## **OXFORDSHIRE COUNTY COUNCIL'S RESPONSE TO CONSULTATION ON THE FOLLOWING DEVELOPMENT PROPOSAL**

**Application no:** 21/03522/OUT

**Proposal:** The erection of up to 540 dwellings (Class C3), up to 9,000sqm GEA of elderly/extra care residential floorspace (Class C2), a Community Home Work Hub (up to 200sqm)(Class E), alongside the creation of two locally equipped areas for play, one NEAP, up to 1.8 hectares of playing pitches and amenity space for the William Fletcher Primary School, two vehicular access points, green infrastructure, areas of public open space, two community woodland areas, a local nature reserve, footpaths, tree planting, restoration of historic hedgerow, and associated works

**Location:** West Of 161 Rutten Lane, Yarnton

FIGURE 24 - MOVEMENT PLAN

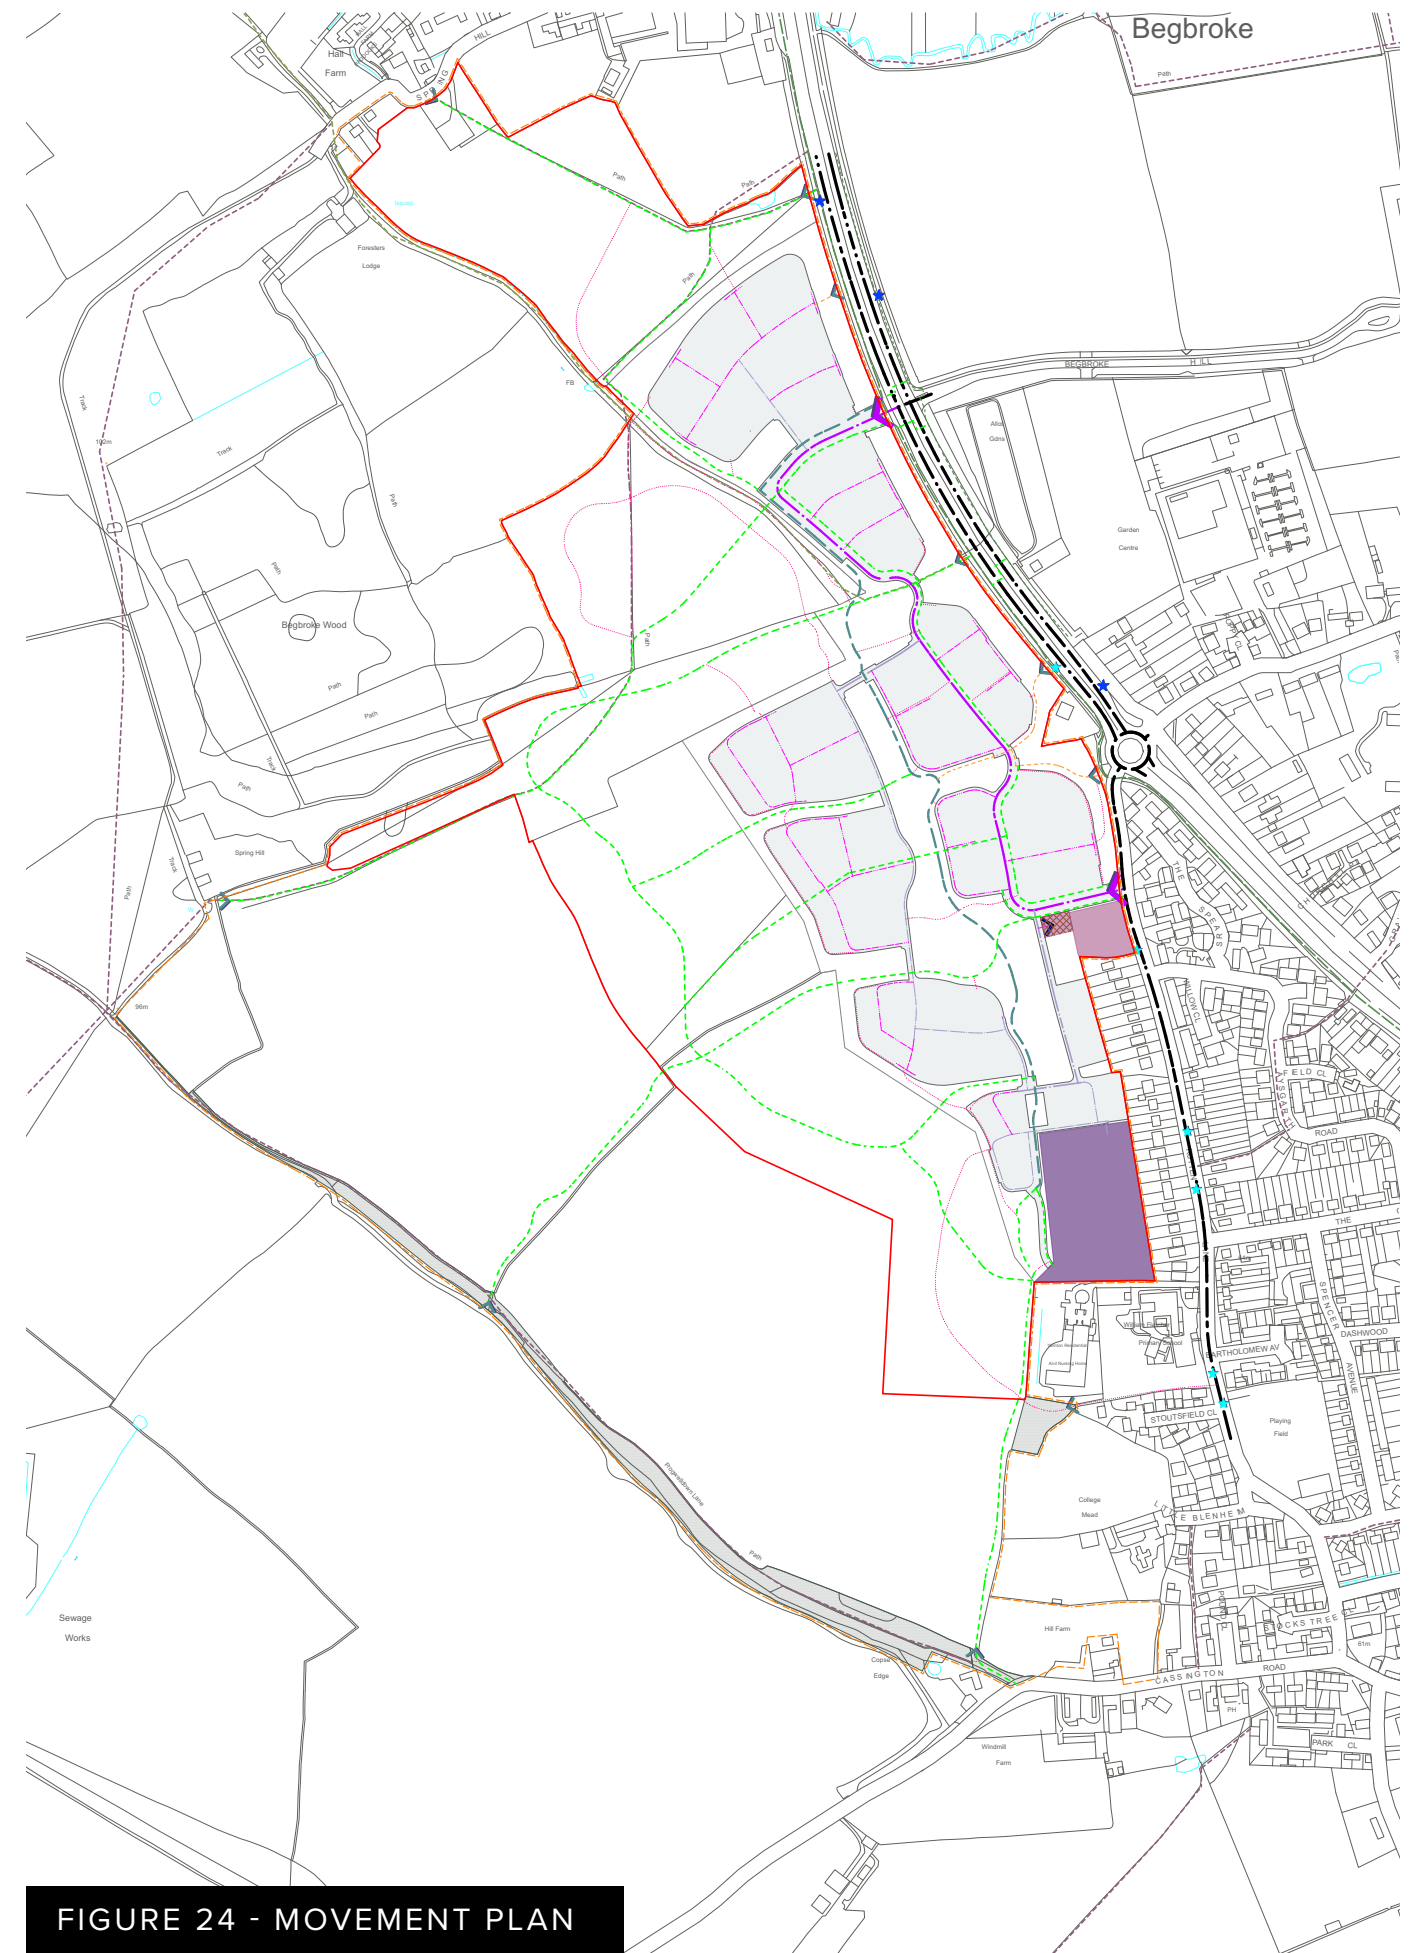
Regarding the site access onto Rutten Lane, while visibility splays have been provided to demonstrate that appropriate visibility can be provided along the horizontal plane, this does not take account of the gradient of Rutten Lane in this location. I therefore request that plans are submitted which demonstrate that appropriate visibility between the site access junction and Rutten Lane can be achieved on the vertical plane, taking account of the gradient of Rutten Lane.

Access to the medical centre is to be altered and taken from the new access road, just within the site. Given the close proximity of the medical centre access junction with the new access road, and the new site access junction with Rutten Lane, it is essential that a good degree of intervisibility between the medical centre access junction and Rutten
